Road Safety Audit Report

Proposed Roundabout along the A325
Holt Pond

Report Title:	Stage 1 Road Safety Audit
Date:	December 2023
Document reference and revision:	RSA-23-140-4
Prepared by:	Fenley Road Safety Limited
On behalf of the Overseeing Organisation:	Hampshire County Council
Design Organisation:	i-Transport
Project Sponsor:	Haskins Garden Centre

DRAWING No: ITB16329-GA-021 REV: F

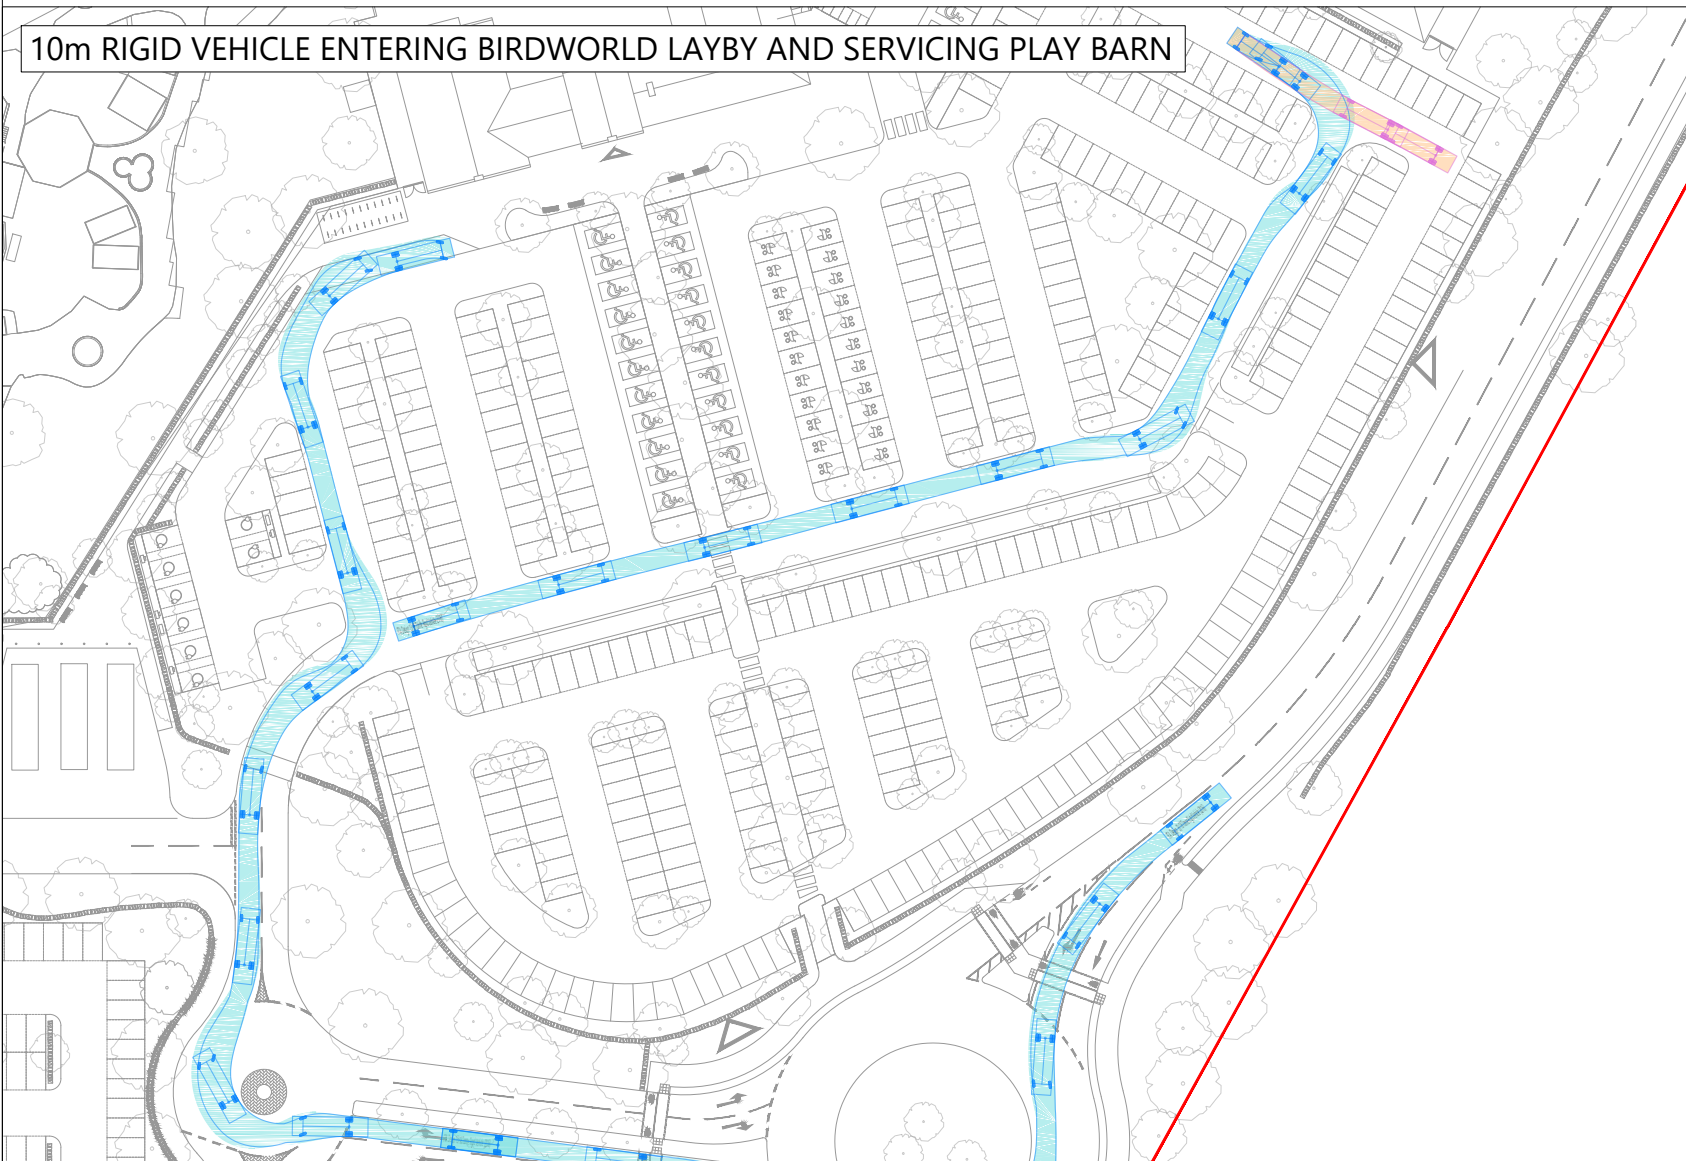
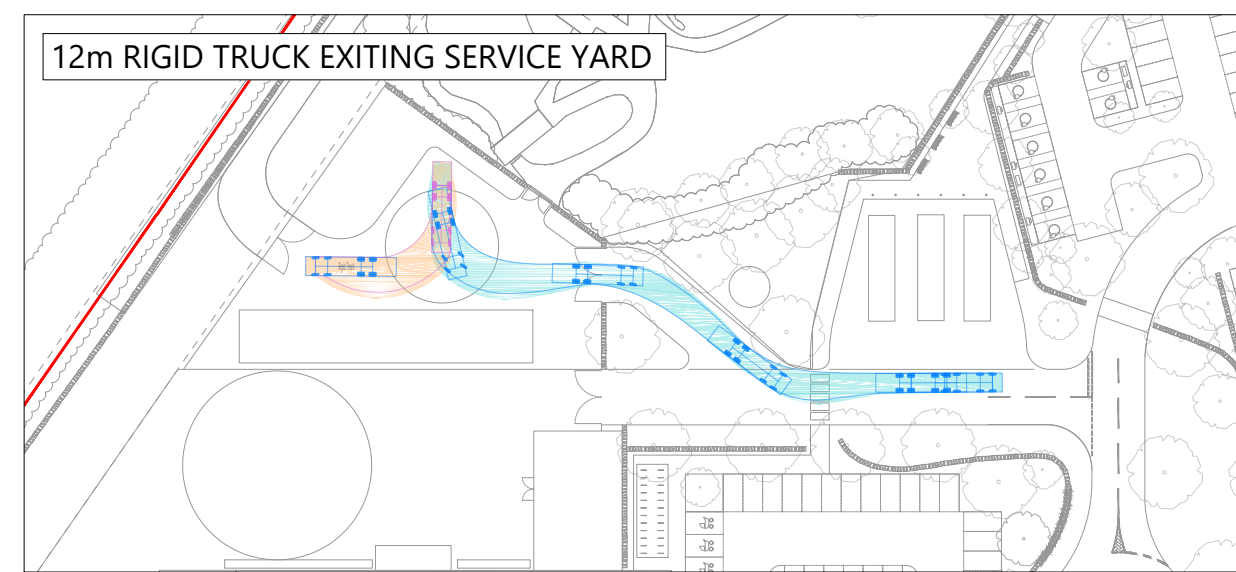
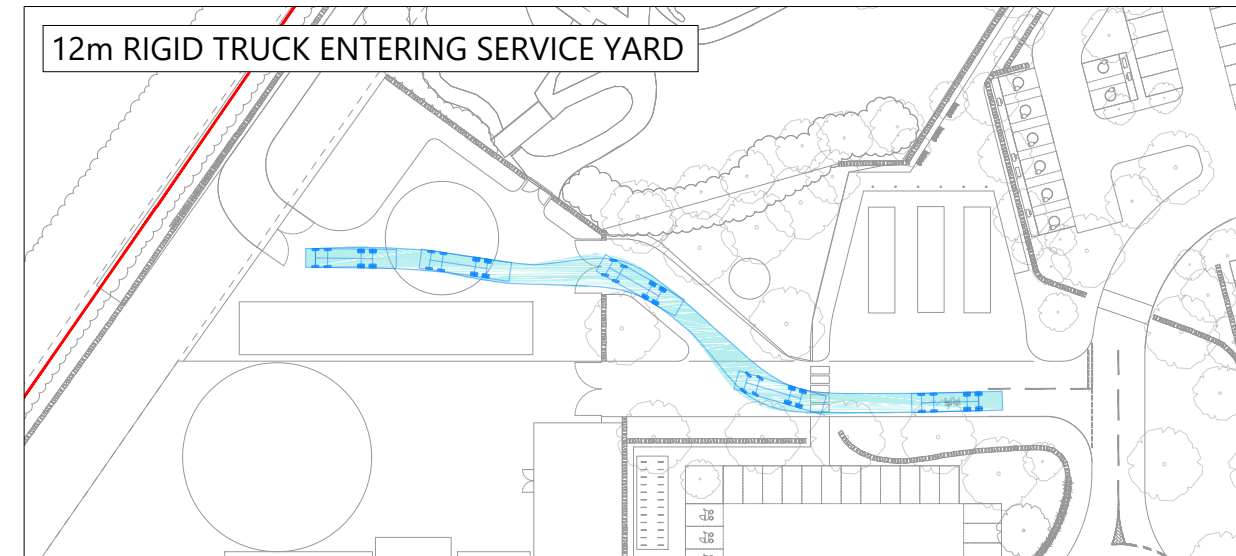
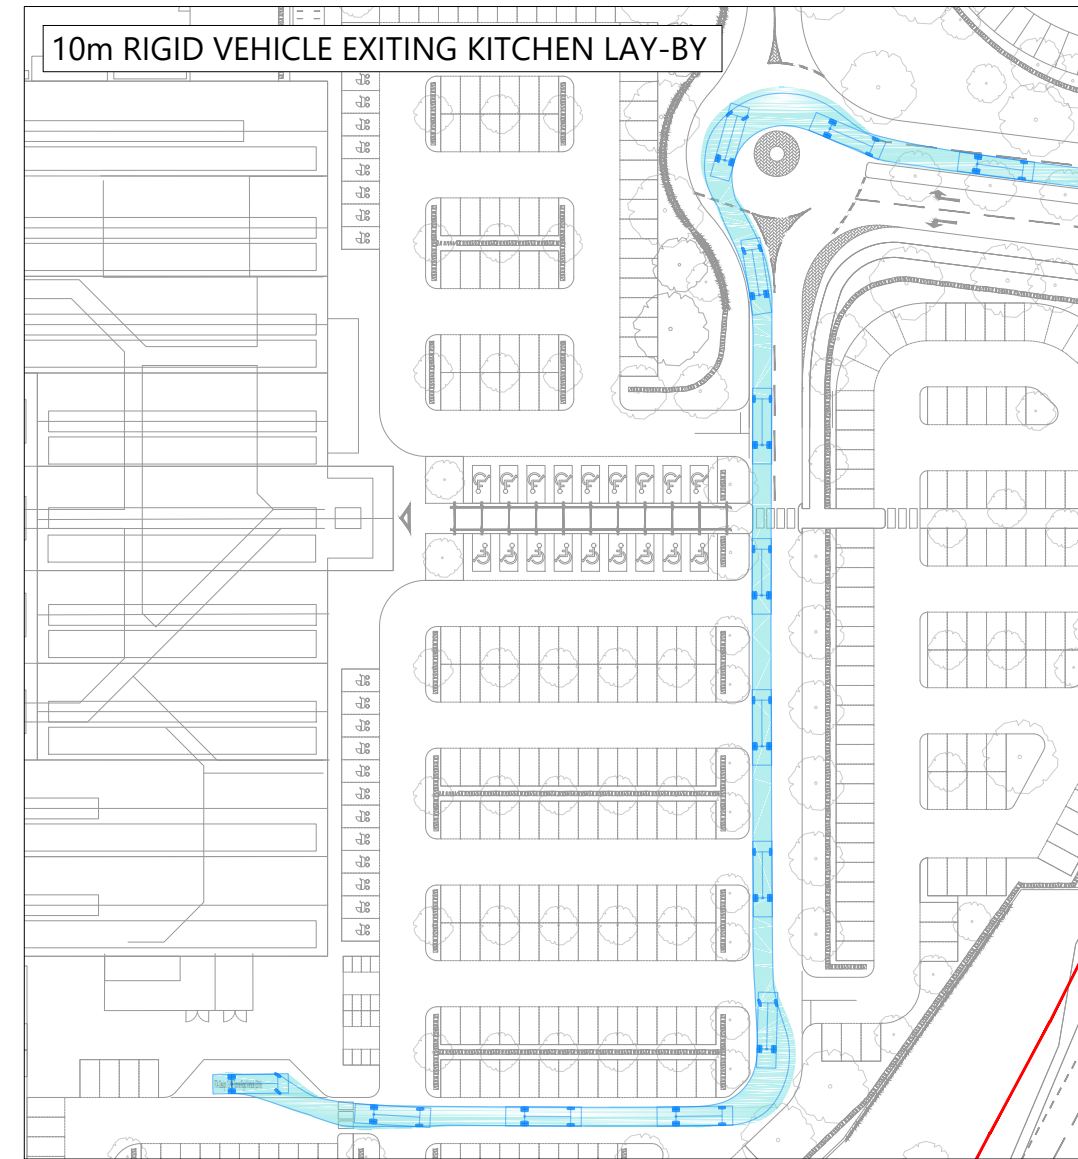
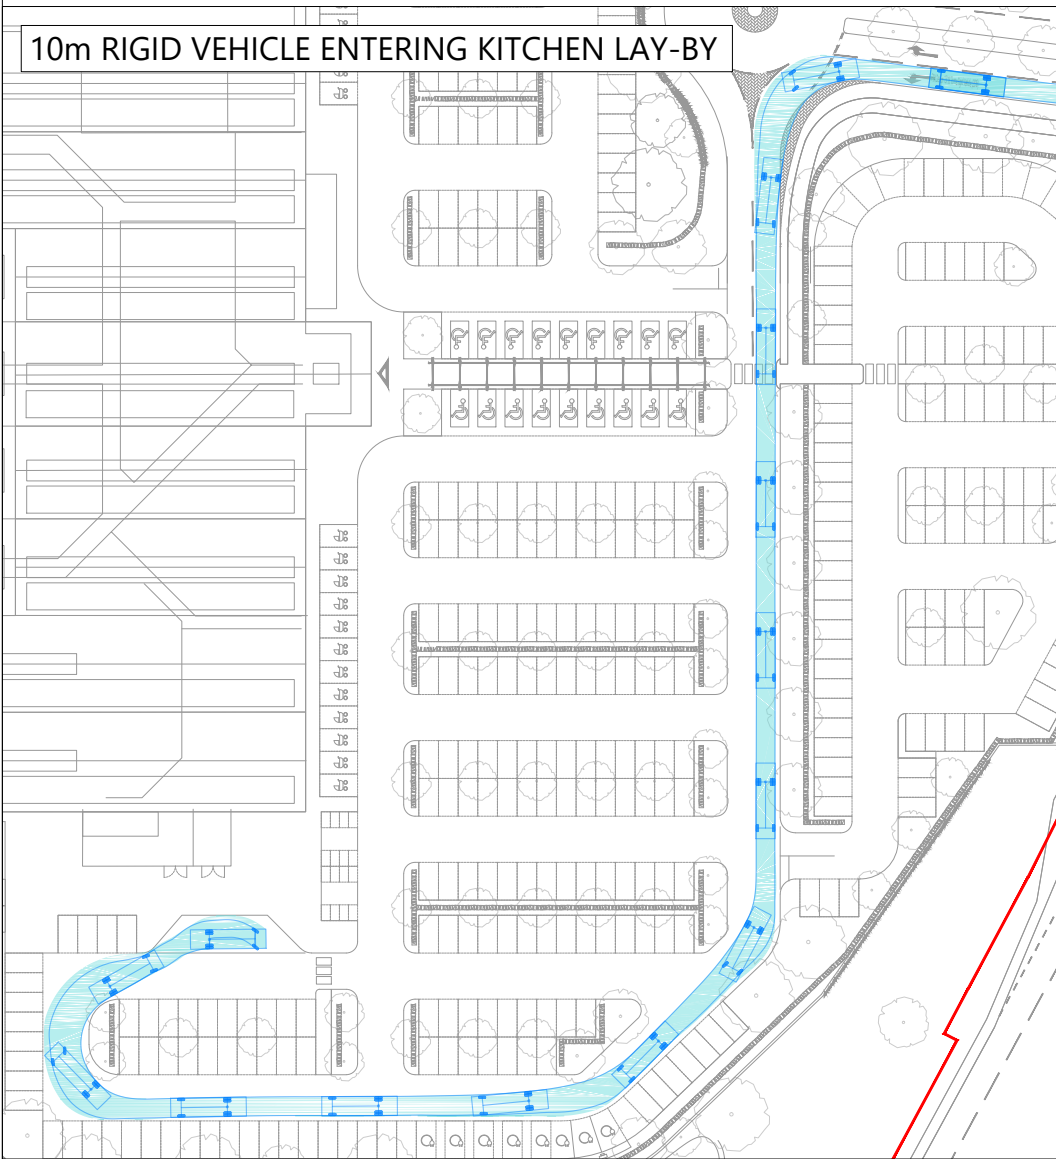
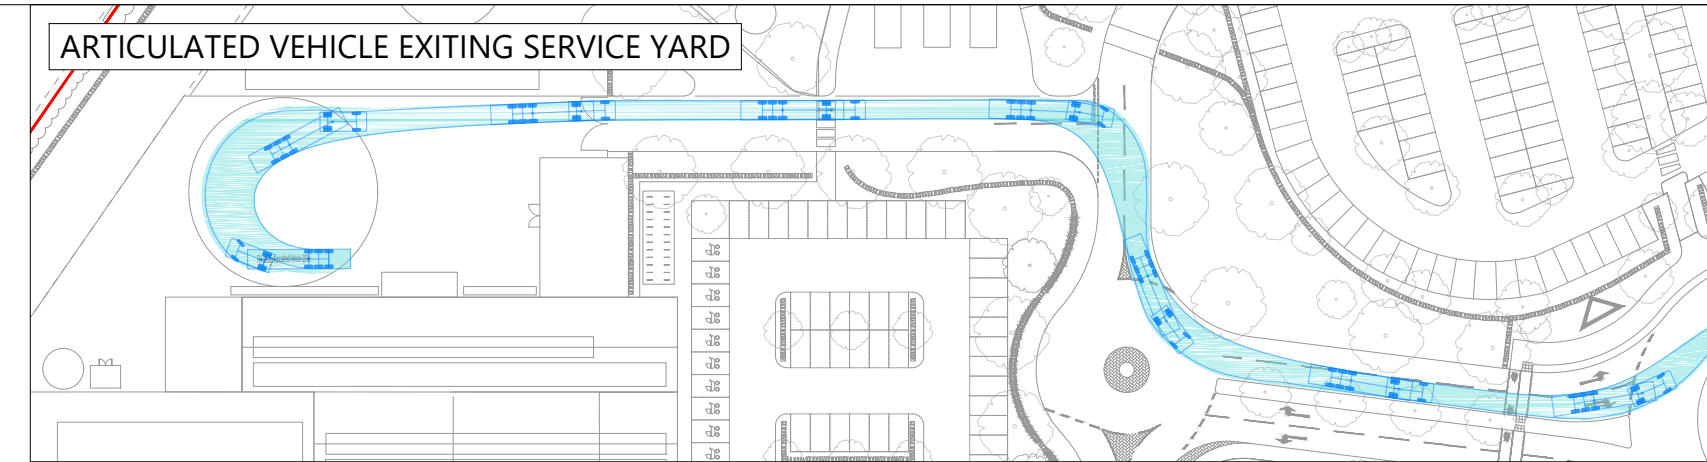
between the A325 and a mini-roundabout serving two separate parking facilities. The scheme drawings illustrate that the proposed garden centre is to be serviced via a simple priority access off the northern arm, however, no swept path analyses have been provided. The Audit Team have concerns that the HGV's will not be able to negotiate the infrastructure which could lead to sideswipe type collisions as well as the vehicles encroaching the footway increasing the risk to pedestrians.

It is recommended that the infrastructure is adequate for the expected vehicles.

Agreed – Vehicle swept path analysis of typical service delivery vehicles likely to be associated with the development has been undertaken and shown on Drawing No. ITB16329-GA-021 and ITB16329-GA-022. This demonstrates that vehicles can enter, turn and exit the internal arrangement including the service areas. Whilst it is noted that some movements result in the overrun of the opposite lane, these movements will be infrequent, in a low traffic speed environment and with good intervisibility in all directions.

Confirmation that the infrastructure is adequate, addresses the road safety concern raised at this stage.
